Future City: G.Mansfield
Reference: ECM # 3579743

23 December 2011

**PORT 3A MAJOR PROJECT (MP08_0130)
MARSTEL BULK LIQUID FUEL STORAGE FACILITY.**

Figure 9: Construction and Operational Access Roads

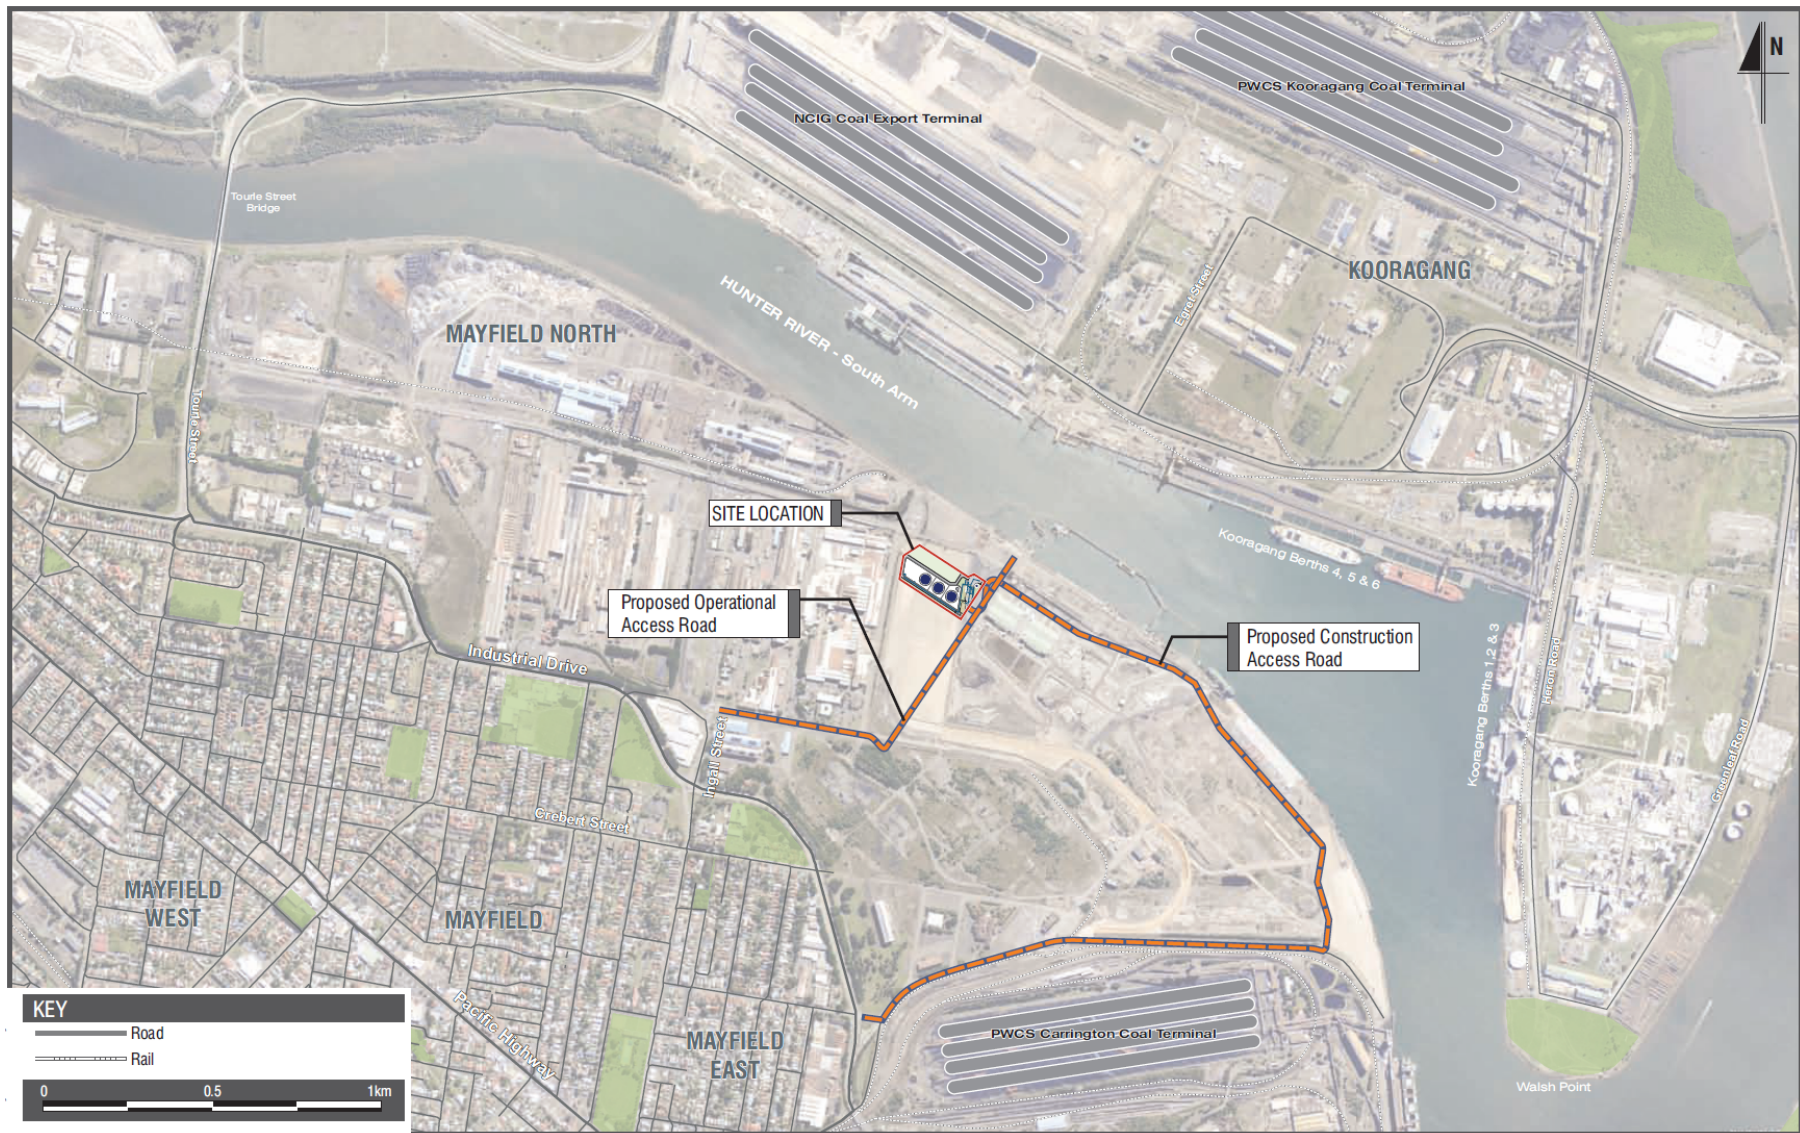
It is noted that Marstel's agreement with NPC is such that the Corporation is required to construct the proposed access roads and intersection improvements and that these works form part of MP 09_0096. Marstel's should be required to commit to constructing these works in the event that MP09_0096 is not approved.

Also, it is noted that Marstel's may utilise the proposed construction traffic access road and Selwyn Street for operations beyond commencement if the other roads are not built by NPC. On 3 September 2009 NPC committed to the provision of street lighting to Selwyn Street and the intersection of the construction access road with Selwyn Street in the event that operations on the port land expanded beyond the 'start up' facilities for which NPC built the upgraded road infrastructure. Operations of the Marstel proposal via Selwyn Street would clearly be an intensification of the use of Selwyn Street beyond the NPC start up facility and hence will require NPC to fulfil their commitment to install the necessary street lighting.
